# Summary of Comments on Microsoft Word - Rocky Top Resources -- deviation turn lane

2.3.7.E 1. Turn Lane Design Elements

Standard 2.3.7.E (Intersections –Turn Lane Design) requires that the westbound left-turn lane into the site have 50 feet of storage, 195 feet for deceleration, and 180-foot taper. There is an existing two-lane bridge located approximately 500 feet east of the access. Accommodating the full auxiliary lane, taper, (and the required lane redirect taper, which would not be modified) would not be feasible given the distance between the access and the bridge.

EXHIBIT A
ROCKY TOP RESOURCES' LEFT TURN LANE LAYOUT

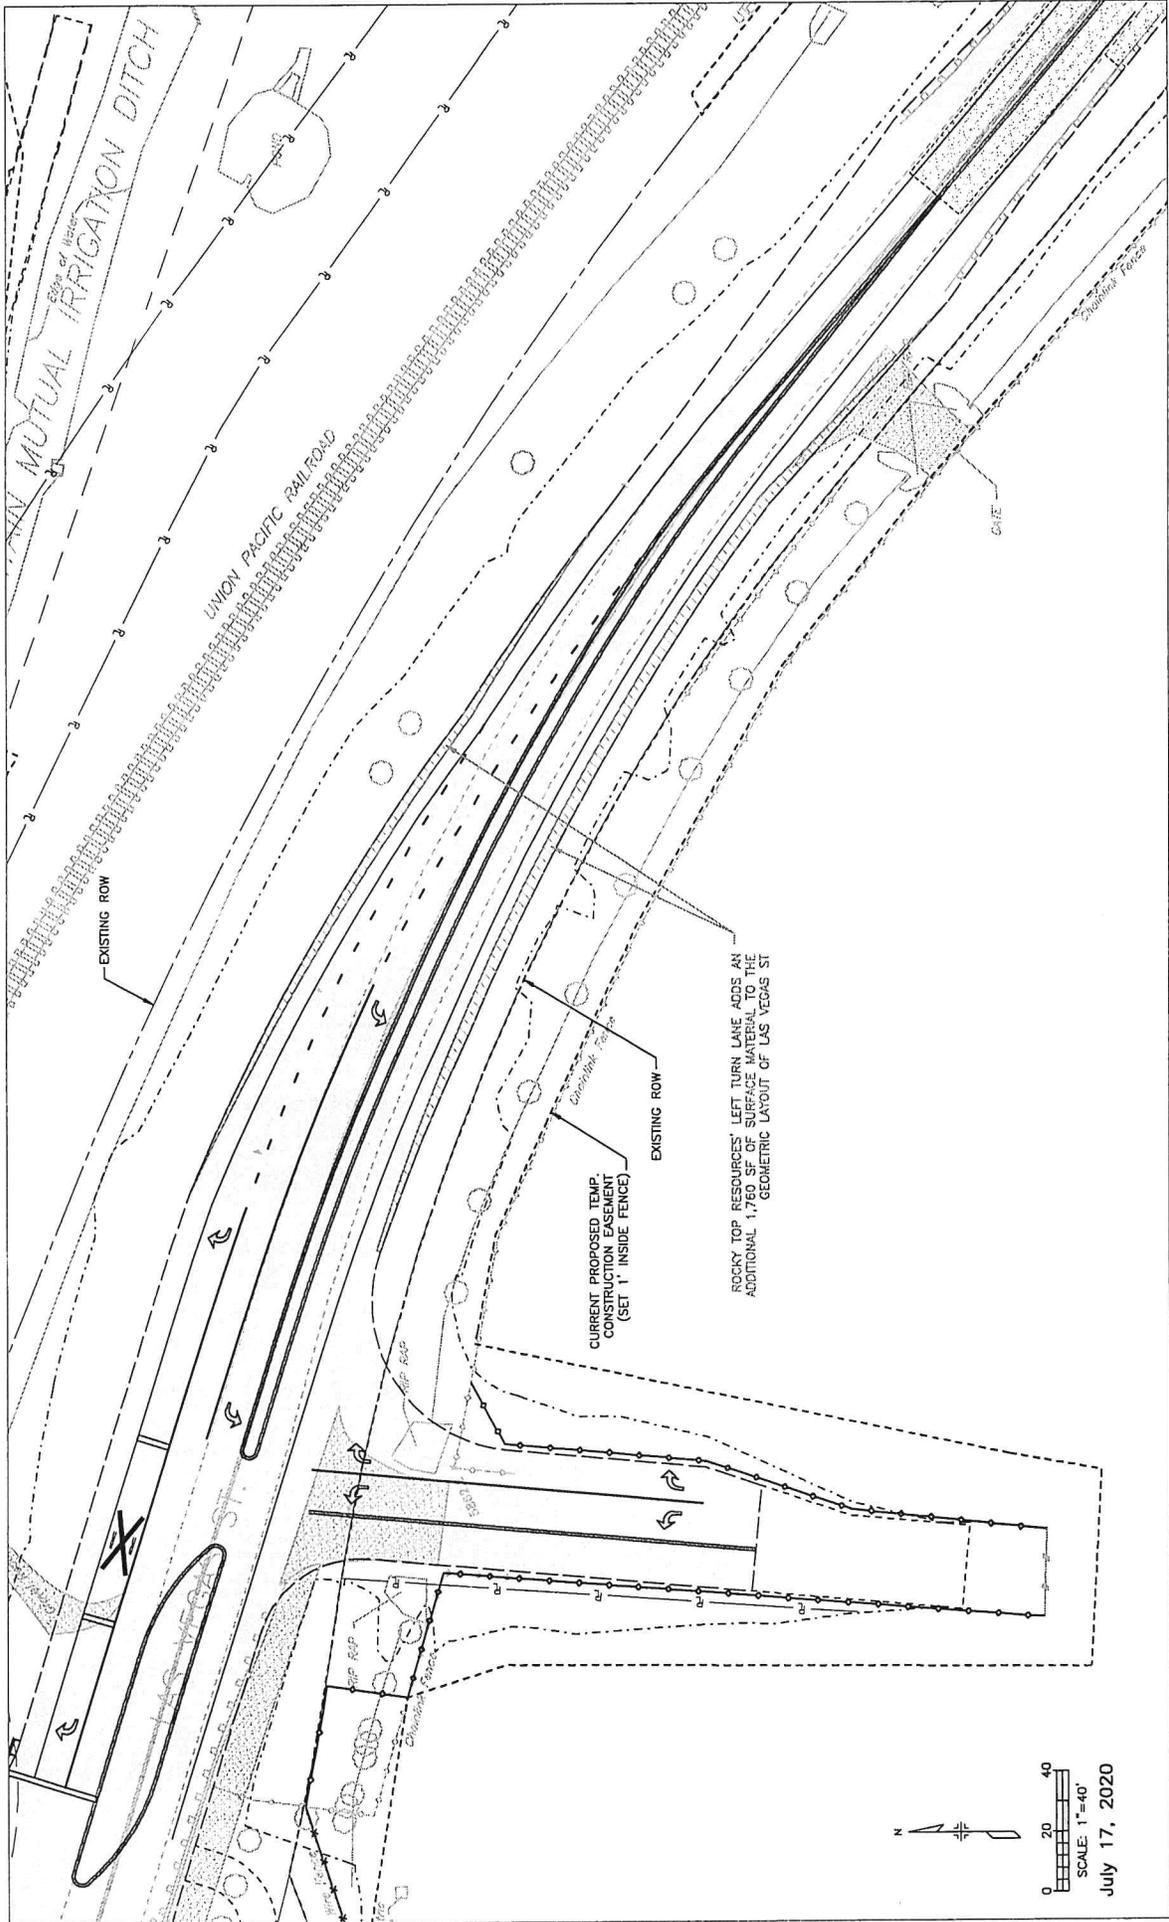
[Please include an exhibit with your deviation request.](#)

Author: cguillotte      Subject: Sticky Note      Date: 4/24/2020 8:28:33 AM  
LSC Response: An exhibit has been added
